### Section 75W Amendment to MP10\_0016 - Scottish Hospital Paddington

This letter constitutes a request to amend the Project Approval for MP10\_0016 (Scottish Hospital Paddington) issued in May 2012 under the former Part 3A of the Environmental Planning (EP&A) Act 1979, and is prepared on behalf of Brookfield Multiplex Constructions Pty Ltd. The application is made in respect to land at 2 Cooper Street Paddington, legally described as Lot 2 DP 607572.

Modification is sought to the approval in respect to eight (8) elements. Each is addressed separately below. Supporting documentation in respect to each of the modifications is provided with this application and is listed against each item for ease of reference.

**Option 3** | Infill Planting of *Waterhousia floribunda* and Transplanted Palms With Staged Removal of Selected Weed Trees

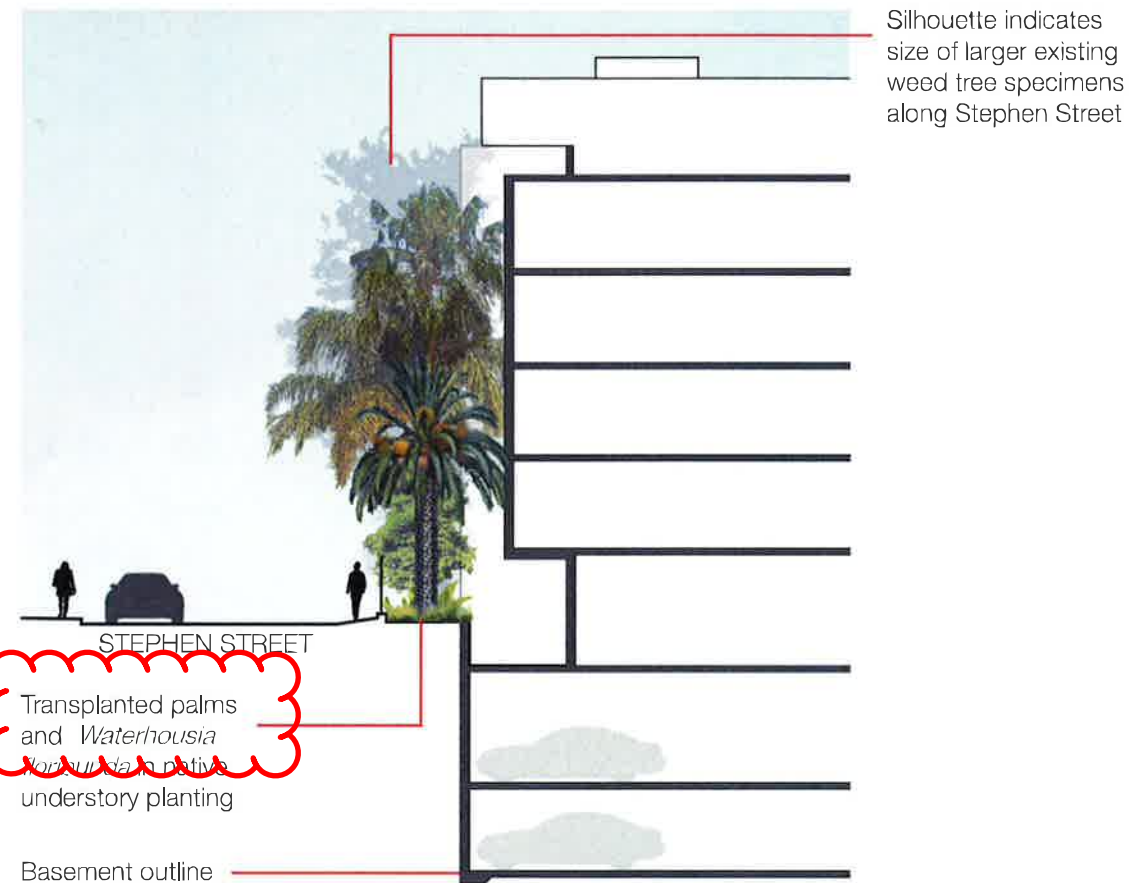
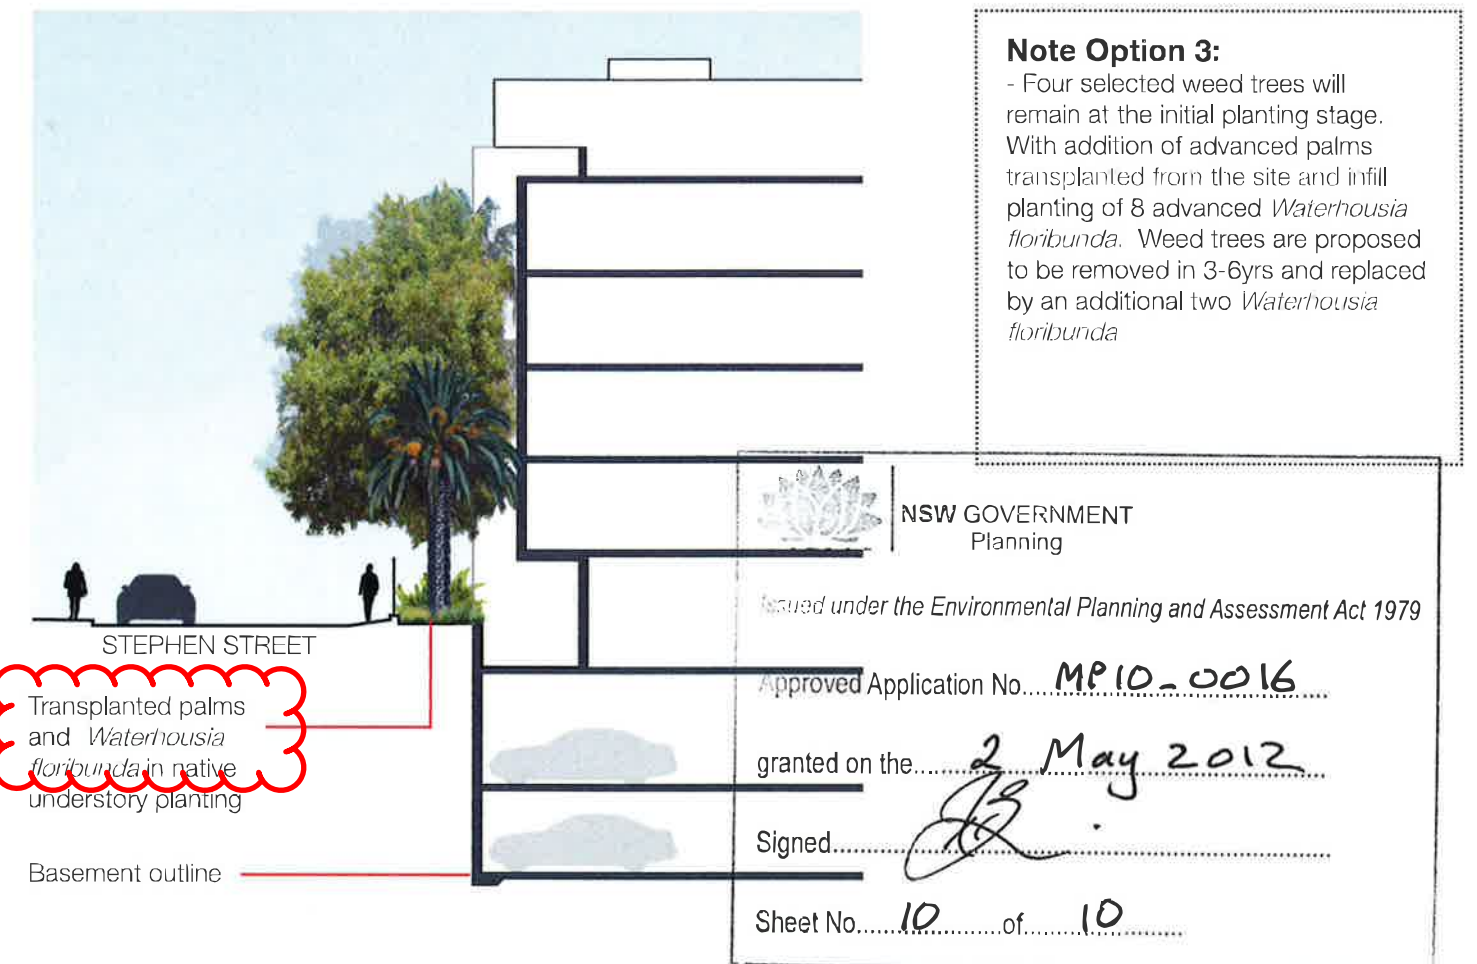
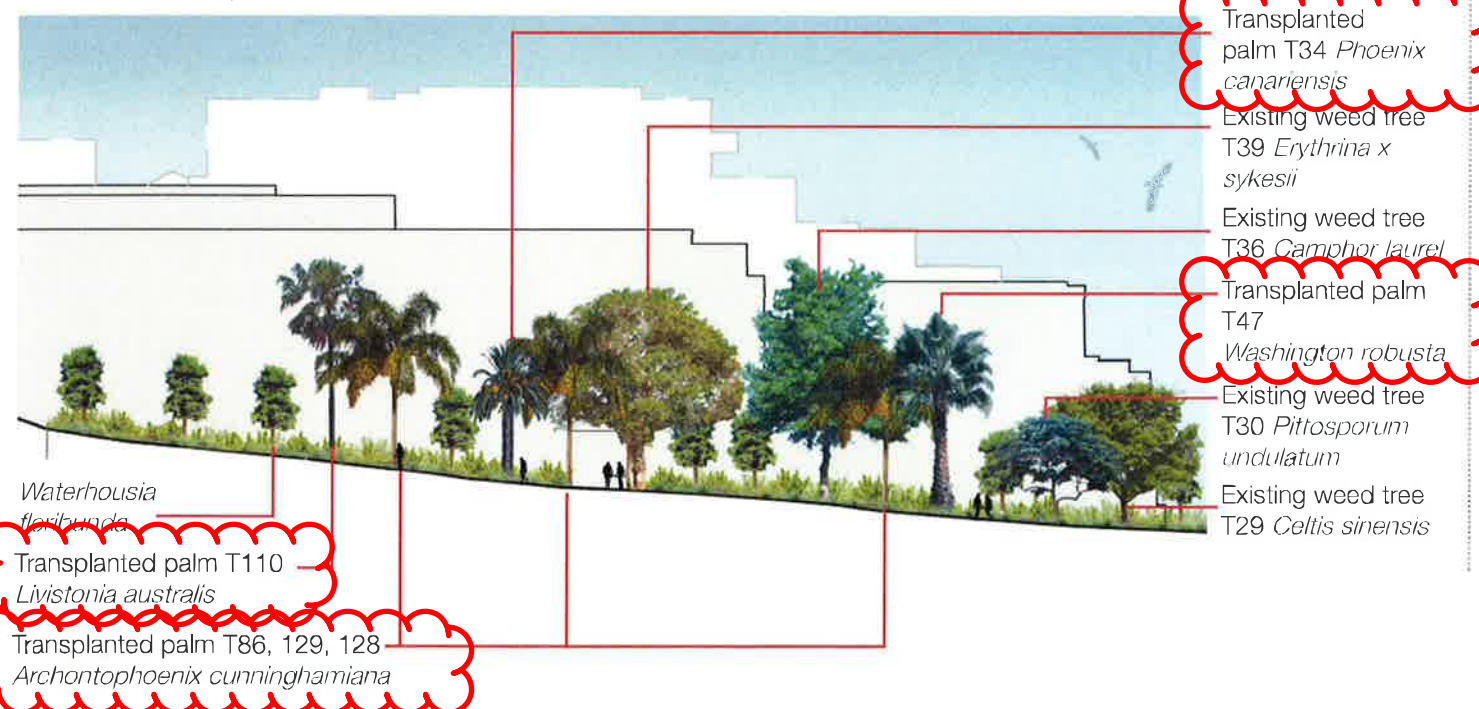
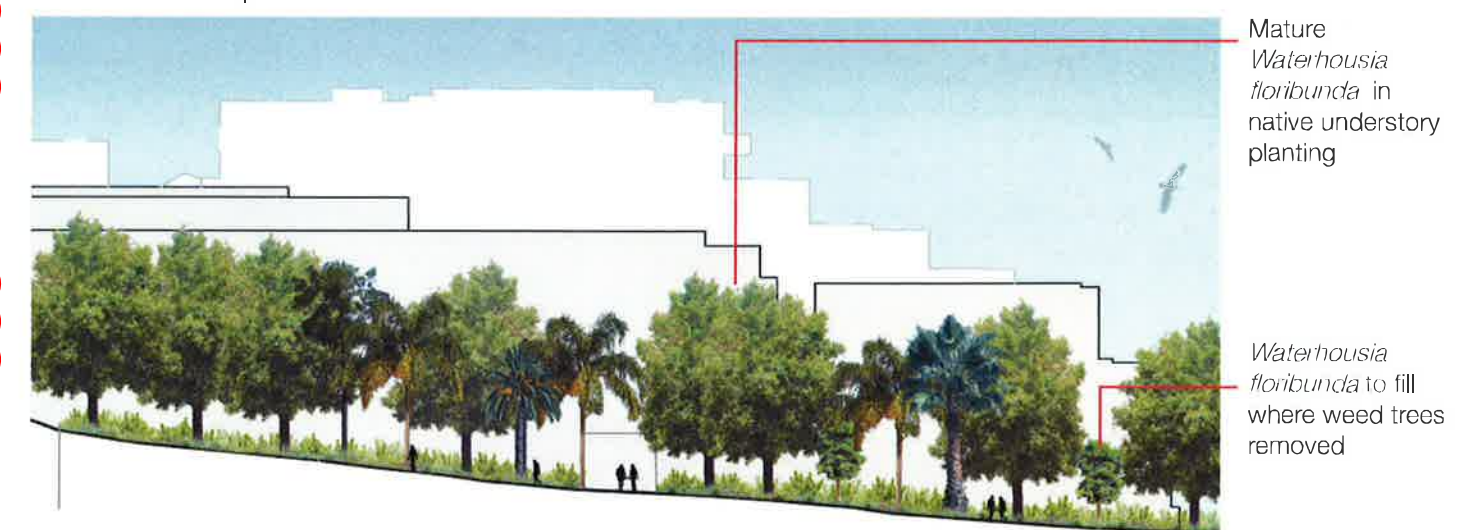
The approval required the relocation of palm trees from within the site to the Stephen Street frontage. Due to the length of time since the approval, the root balls of the subject palm trees have grown and will cause issues with respect to services reticulation and overland flow.

It is proposed to replace the palm trees along Stephen Street with Weeping Lilly Pilly *Waterhousea floribunda* which will provide increased screening, and locate the subject palm trees to the landscaping of the exercise area shown on the Site Image drawings.

DRAWING NO:	REV:
<b>A-B-1111</b>	<b>8</b>

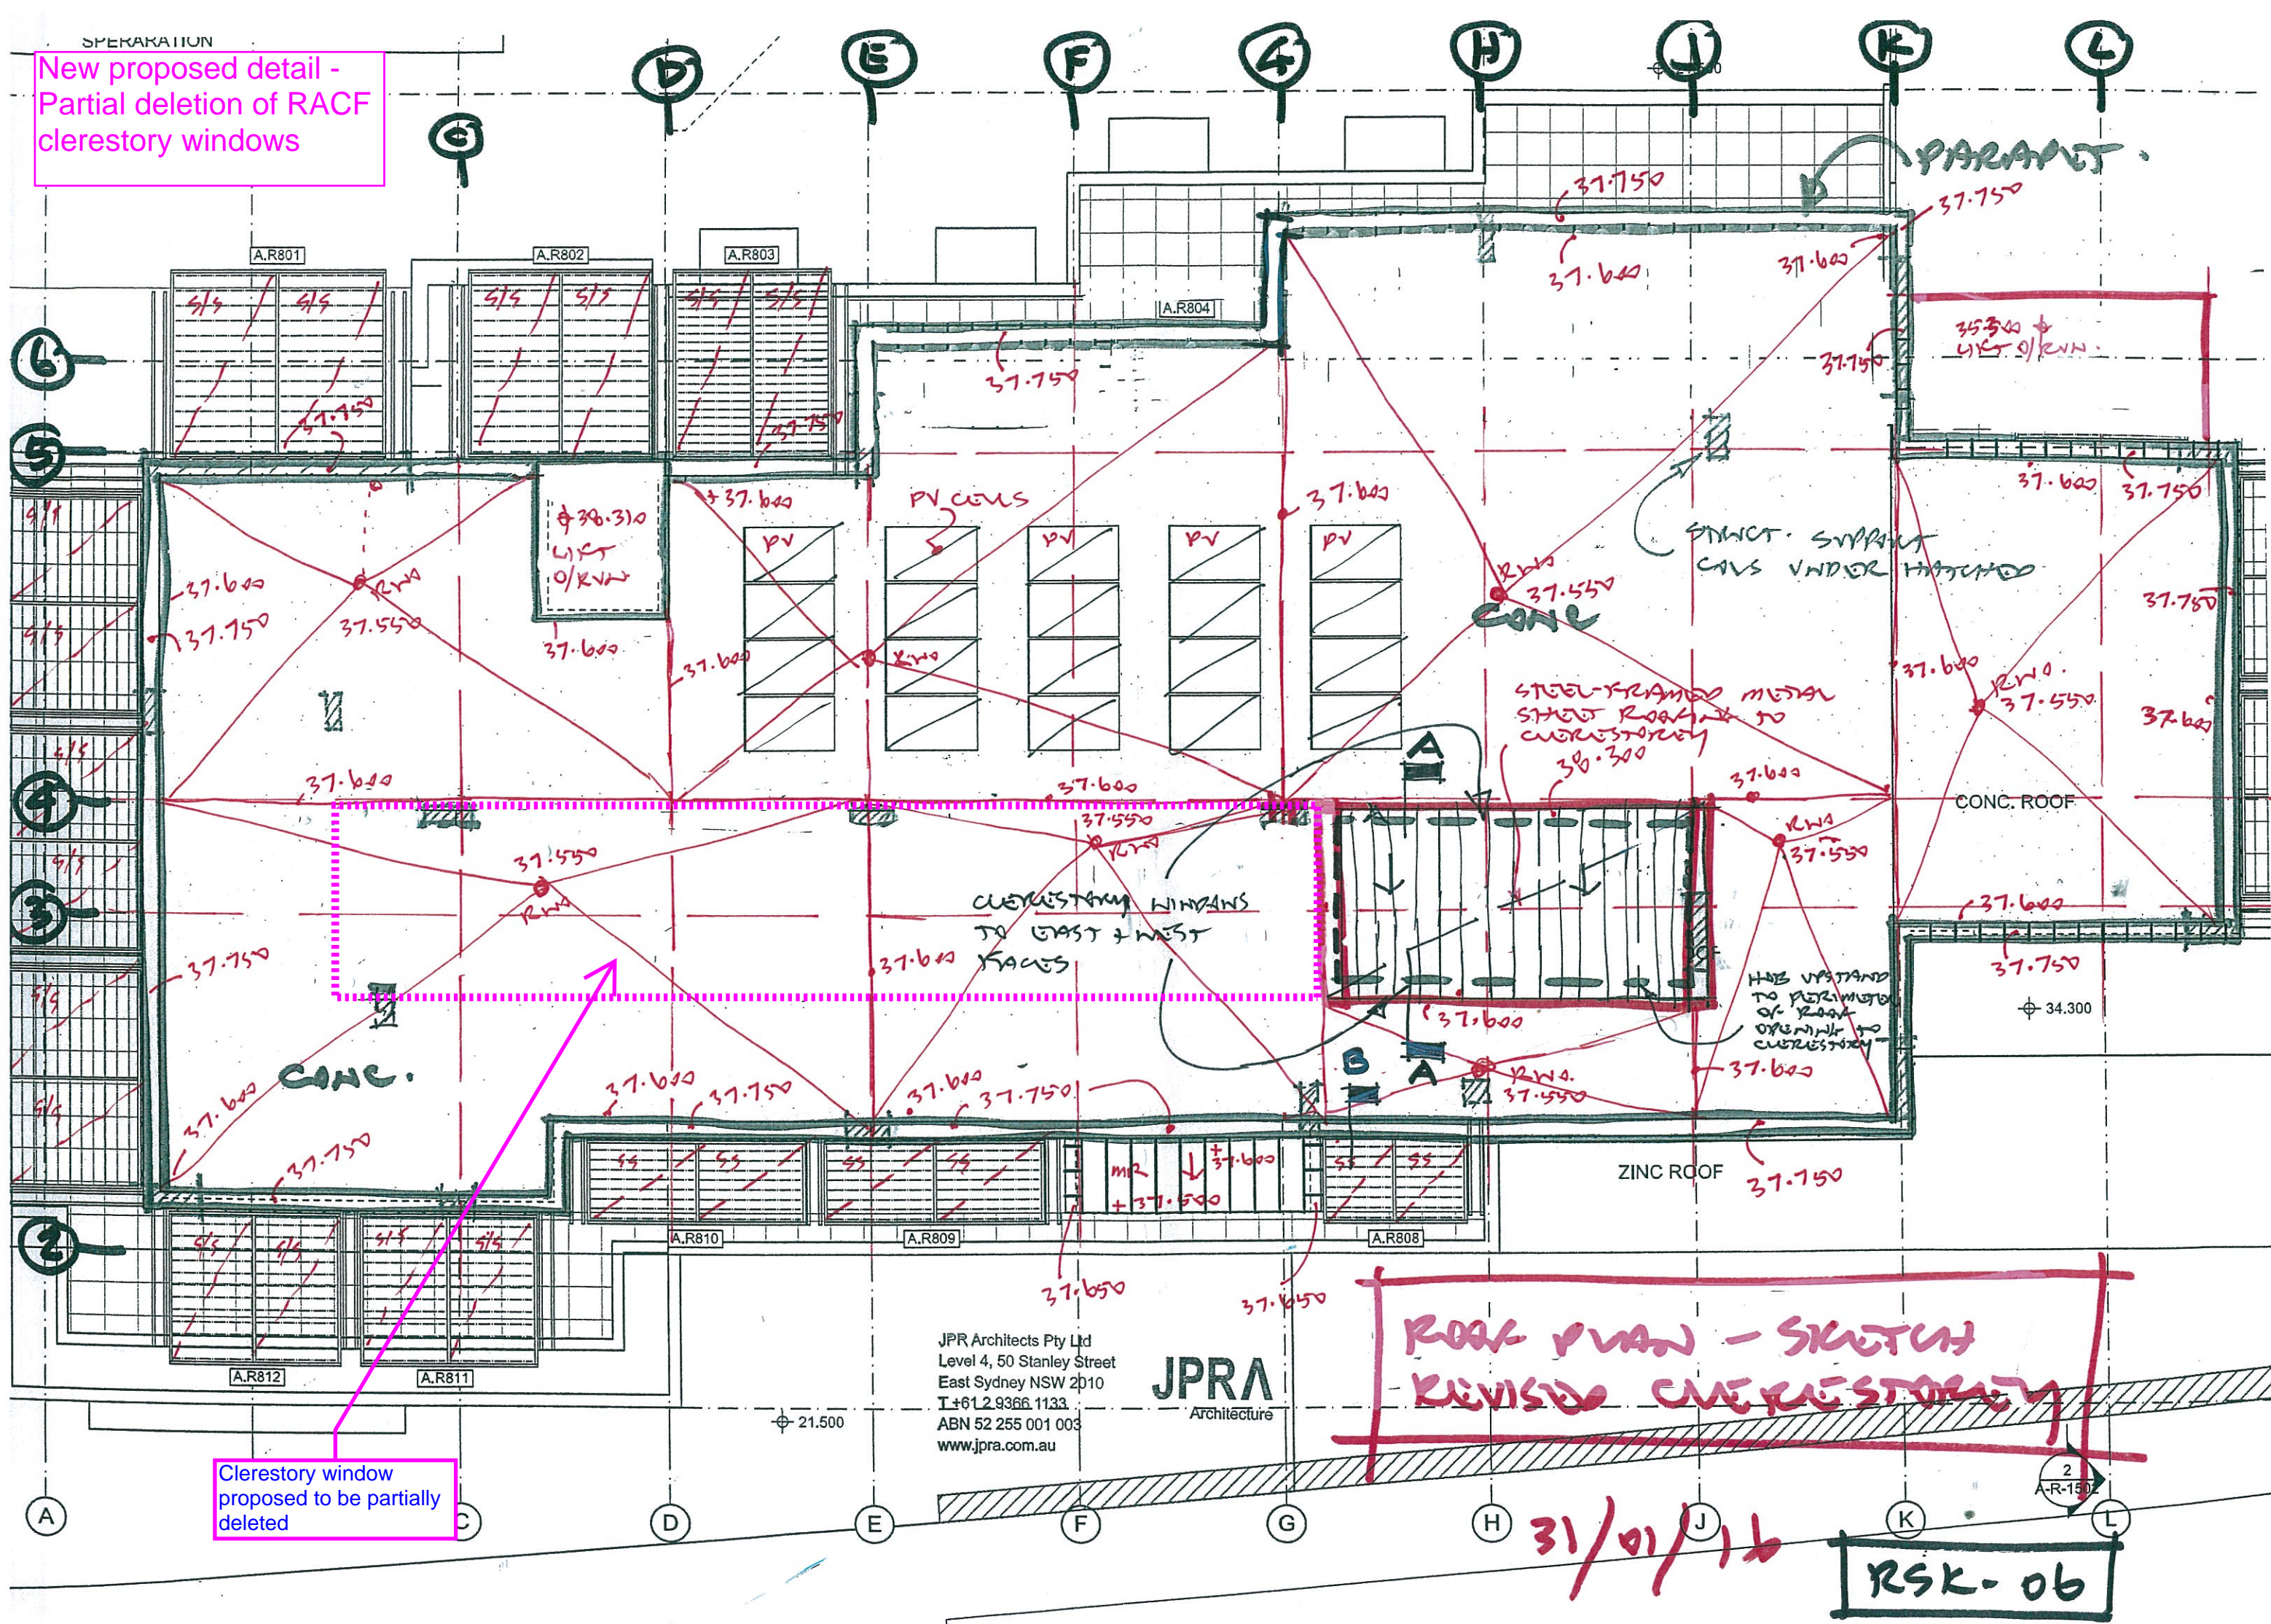
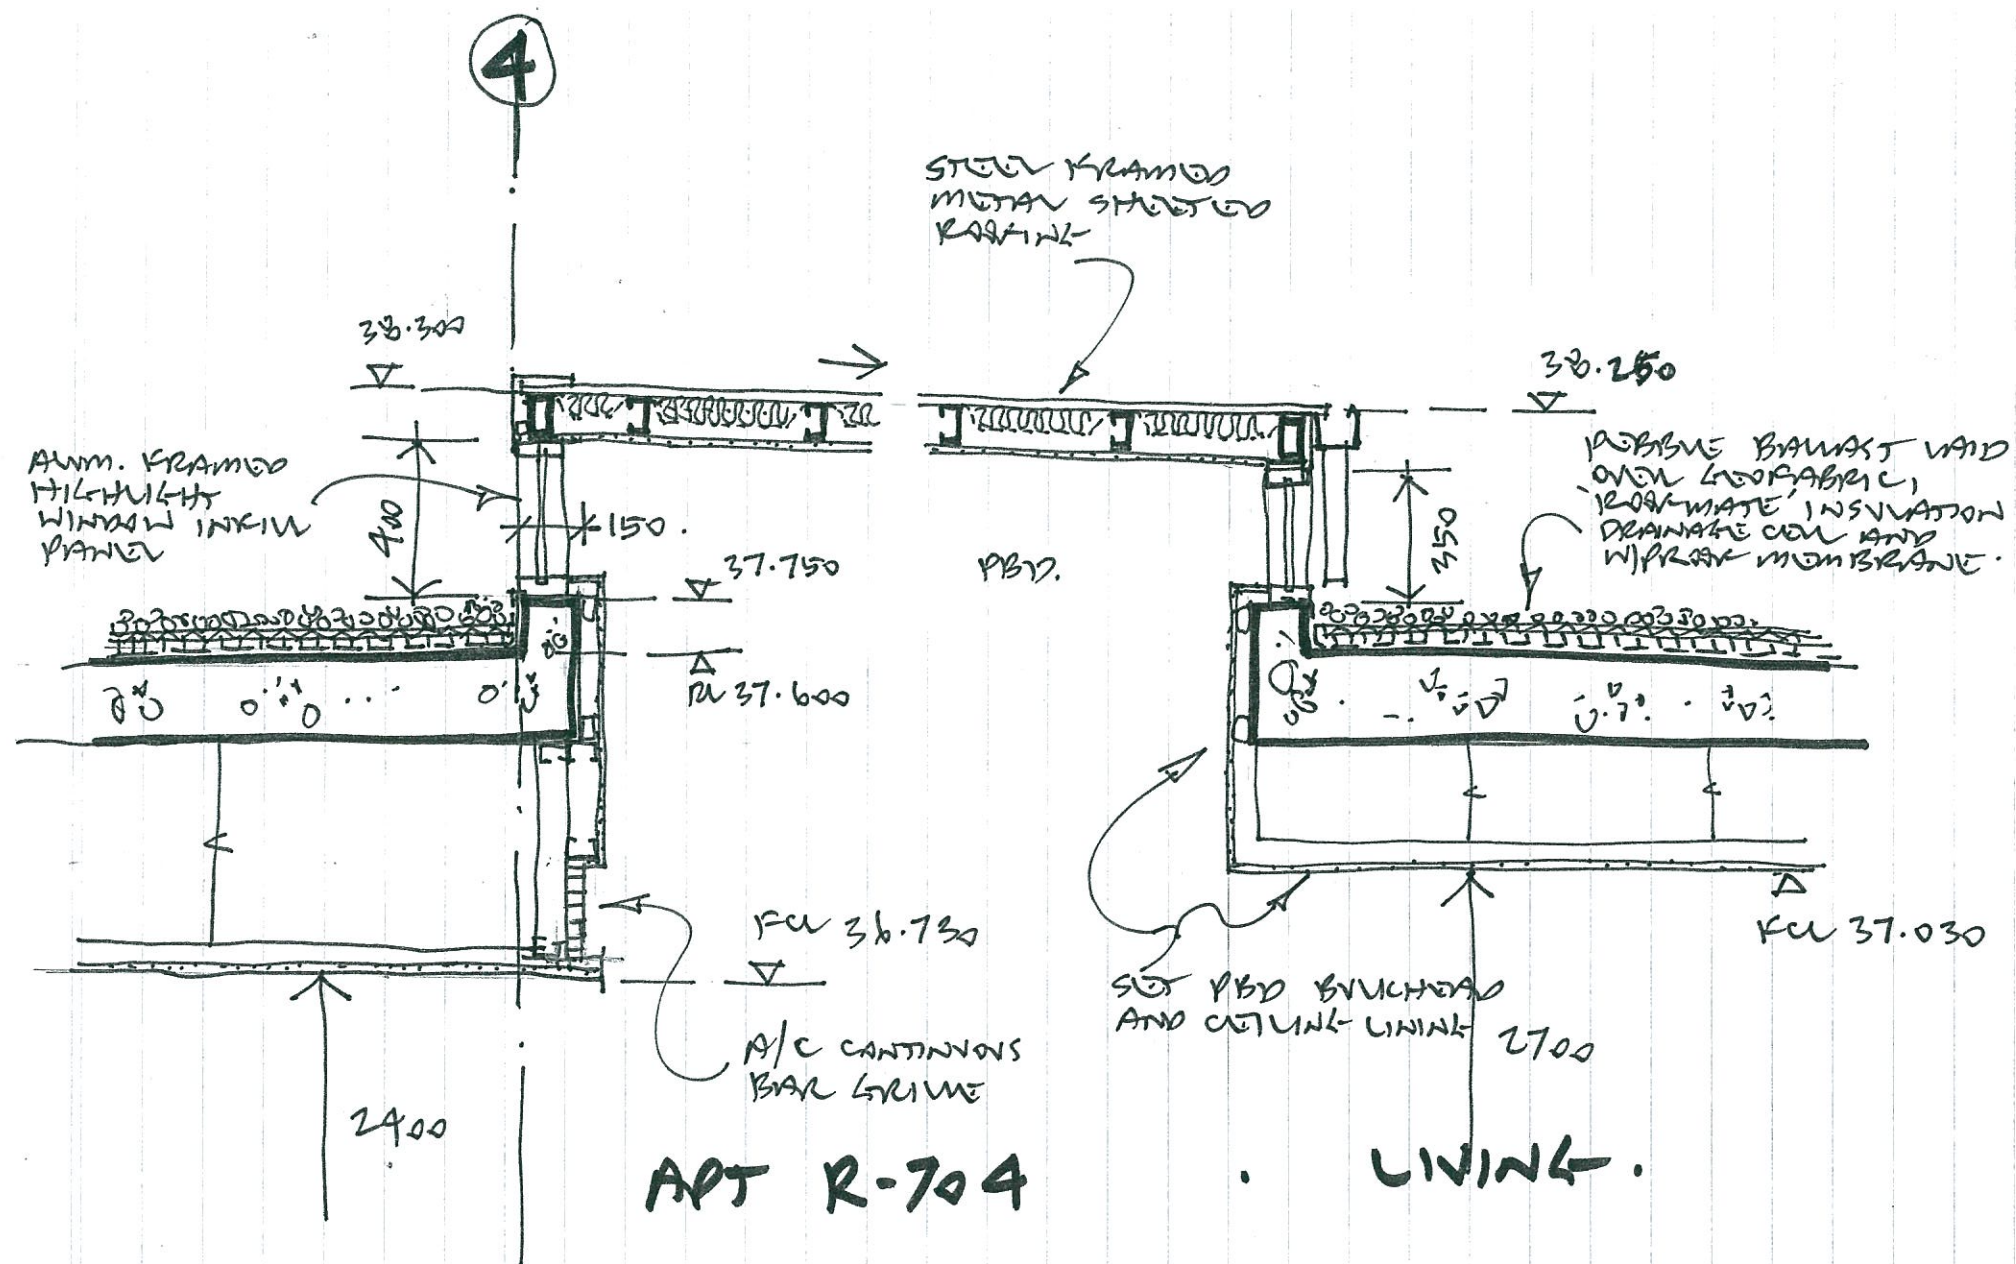
It is proposed that there be a partial deletion of clerestory windows on the Stephen Street RACF Building and full deletion of clerestory windows on the Brown Street building.

This amendment is proposed to improve the longevity of the roofing materials, as well as to resolve a disalignment of the clerestory with the floor plan below. The clerestory windows in their approved location currently do not serve any purpose or provide any sunlight benefit to the upper level residences.
